CITY OF ALBUQUERQUE

Site: Los Diamantes Subdivision

Re: Drainage Ordinance (14-5-2-1) Violations for Erosion and Sediment Control and Construction Site Waste(s)

LOS DIAMANTES SUBDIVISION
GRADING & DRAINAGE PLAN

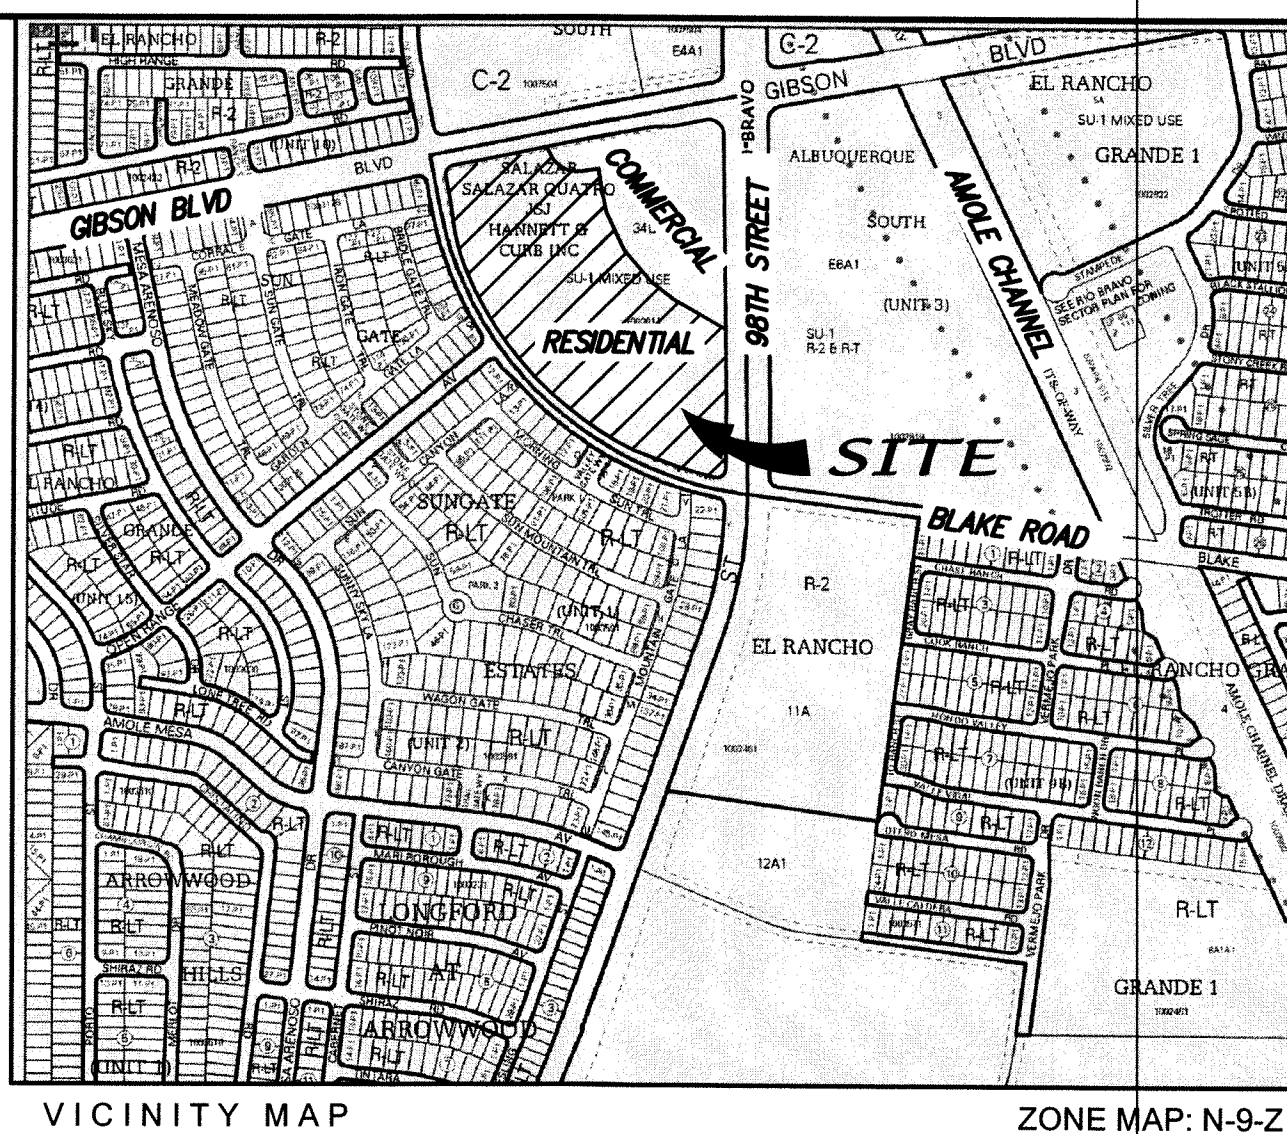
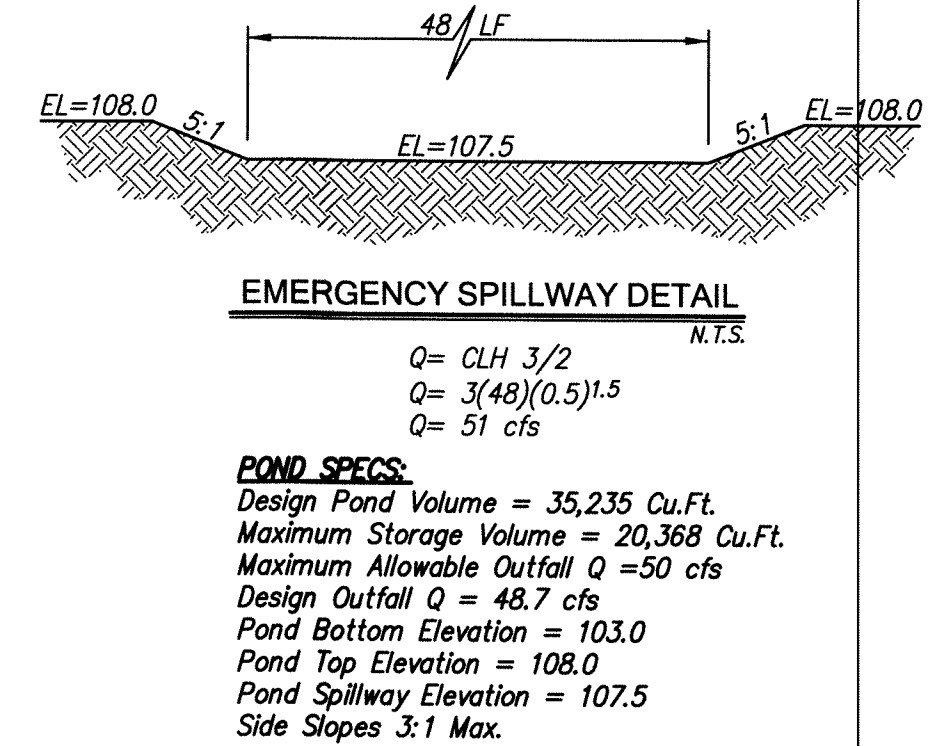
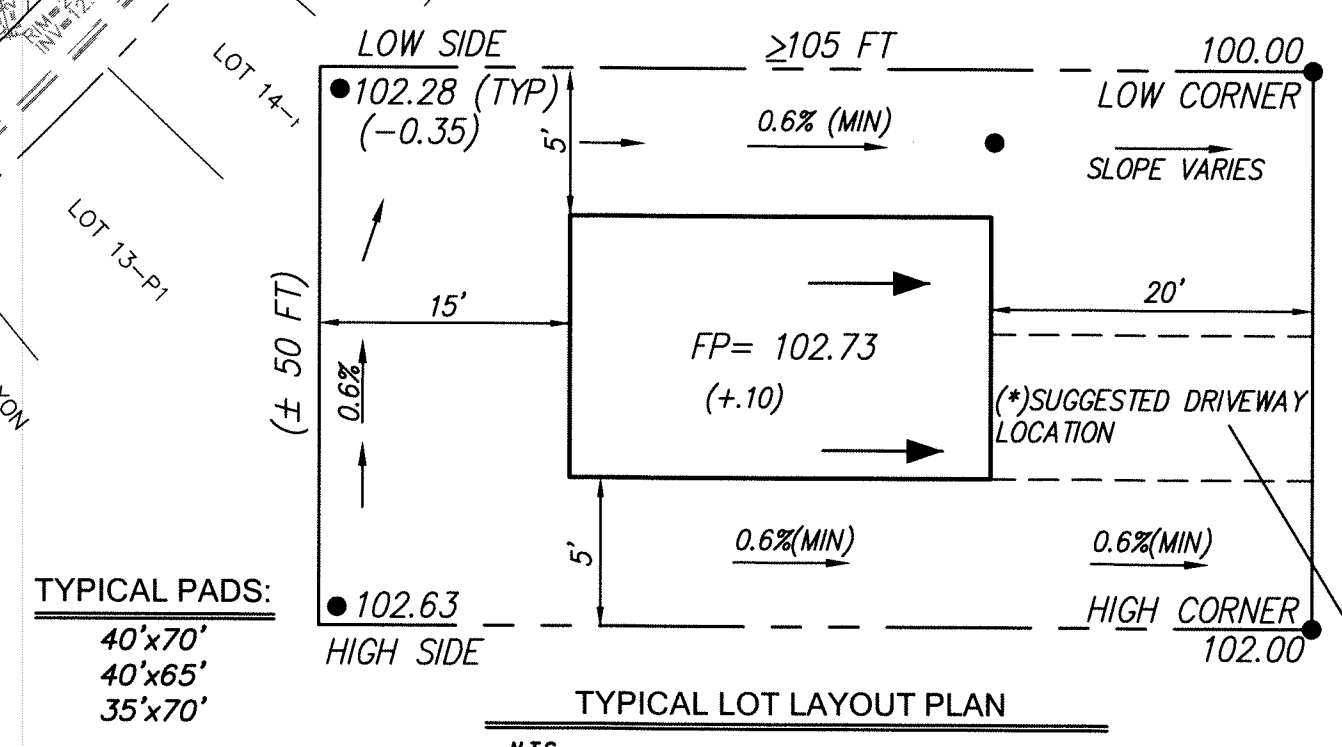
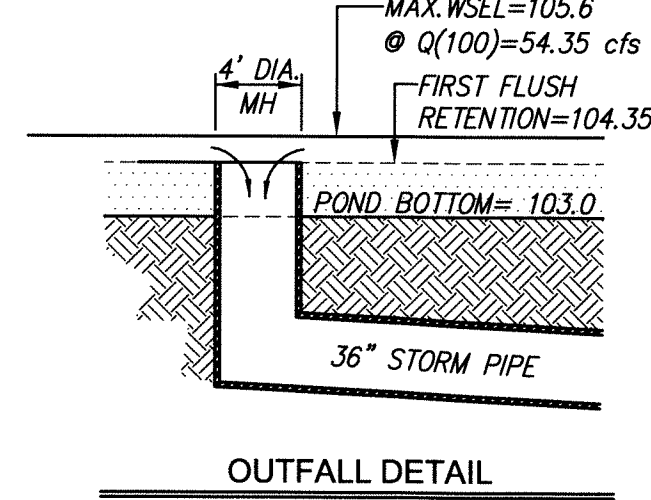
1. The pond outfall did not have inlet protection and sediment entered the City's Drainage system in this location.
2. There was a dirt pile in the gutter of Blake Rd and no sediment BMP in this location.
3. Vehicles are exiting the site onto Blake Rd and there is no track-out pad.
4. Wash-out in the pond and other locations.
5. The track-out pad requires maintenance.
6. Sediment in 98th St and Blake Rd.
7. The silt fence on Blake road requires maintenance.
8. Inlet protection in Blake Rd and Gibson Blvd require maintenance.

1. Provide inlet protection for the pond outfall. Protection to be a minimum of 15 inches high. A filter sock pyramid may work the best.
2. Remove the dirt pile in the gutter of Blake Rd and provide a sediment BMP in this location to prevent sediment from leaving the site as well as a BMP for the area where the gutter has been removed.
3. Prevent vehicles from exiting the site onto Blake Rd or provide a track-out pad.
4. Remove wash-out from the pond and other locations. Provide a wash-out facility for wall builders close to work areas. An Outpak may work the best as the work areas move.
5. Maintain the track-out pad.
6. Remove sediment from 98th St. from the entrance area on 98th St. to approximately 100 feet south of Blake Rd.
7. Remove sediment from Blake Rd near the dirt pile.
8. Maintain the silt fence on Blake Rd.
9. Maintain the inlet protection in Blake Rd and Gibson Blvd.
